Our Ref: BE/187/16/HH

**Town & Country Planning Act 1990 (as amended)
Town & country Planning (Development Management Procedure) (England) Order 2015
Application for Householder Planning Permission**

Development Two story rear extension to property, to provide added living space and fourth bedroom
Location 6 Sunningdale Gardens Bersted

6 SUNNINGDALE GARDENS GROUND FLOOR SCALE 1:100

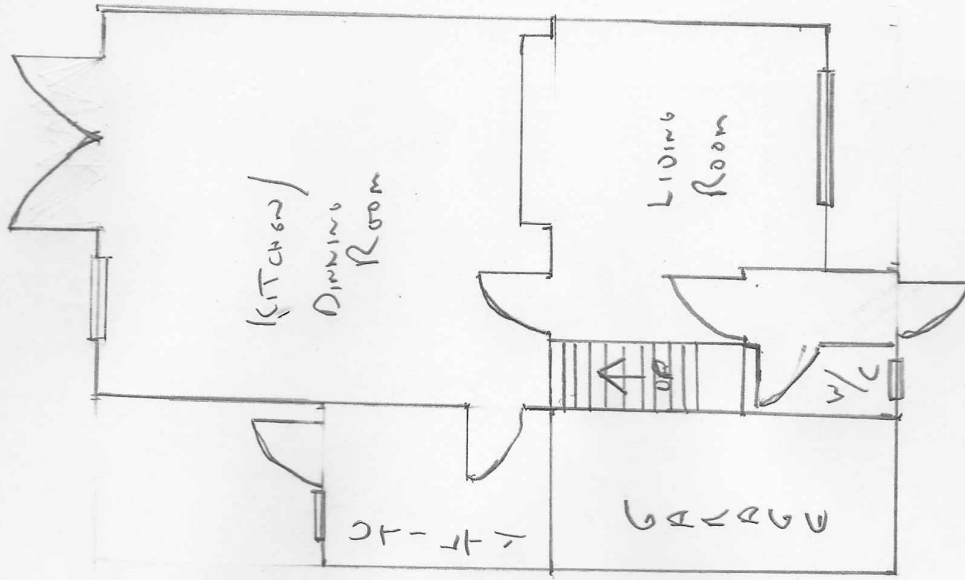
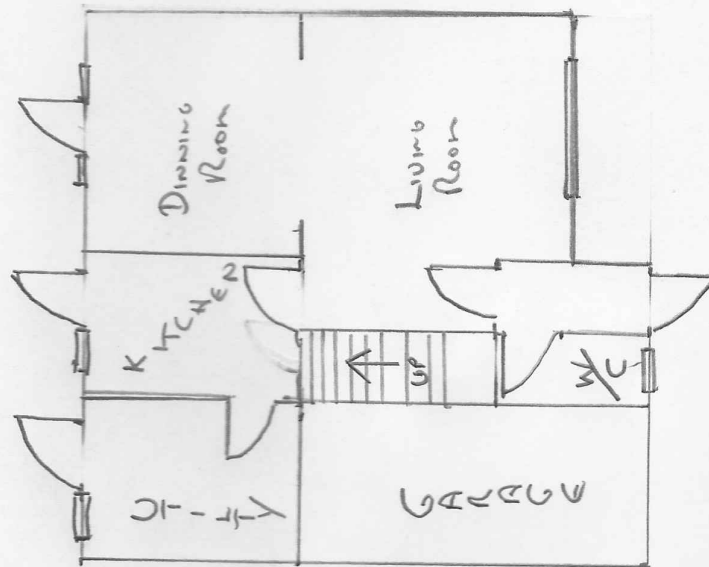
The position of the windows/doors are inconsistent between the proposed ground floor plan and rear elevation

6 Sunningdale Gardens ELEVATIONS Scale 1:100

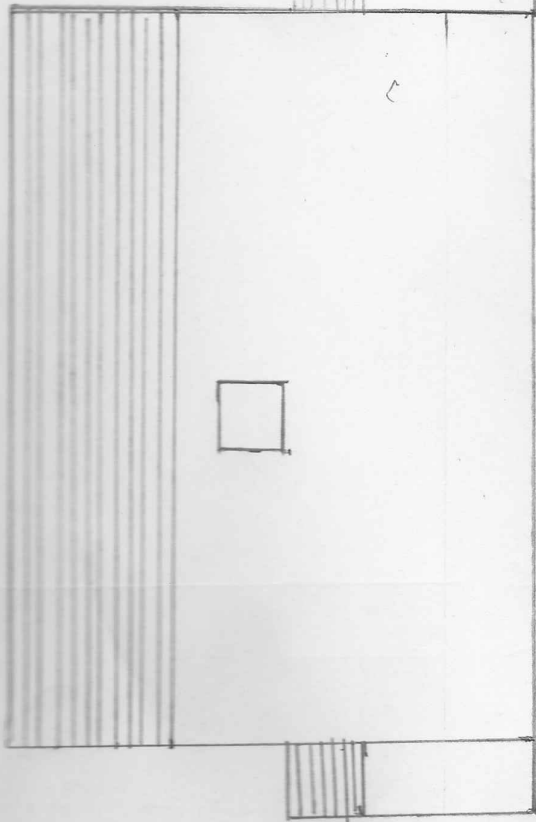
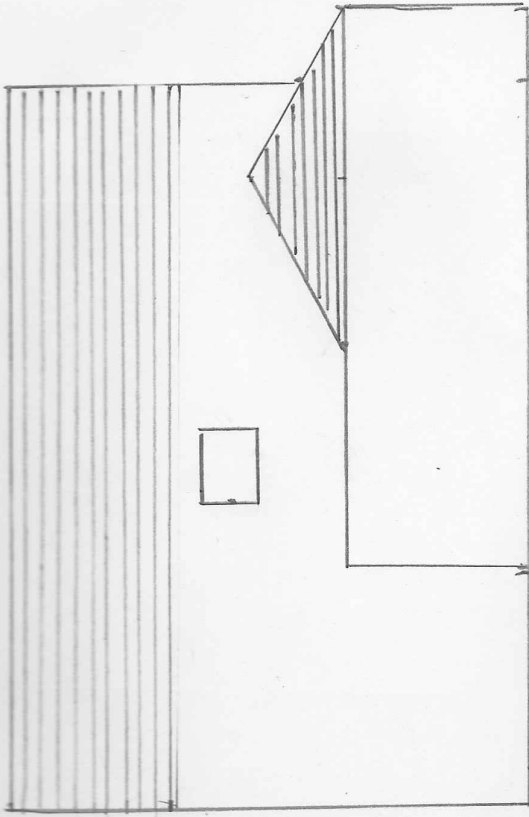
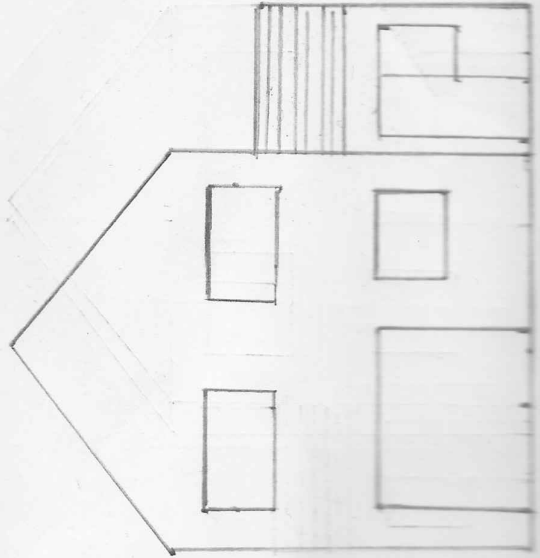
Both front and rear elevations are showing the garage on the left. This is incorrect. Please amend accordingly;
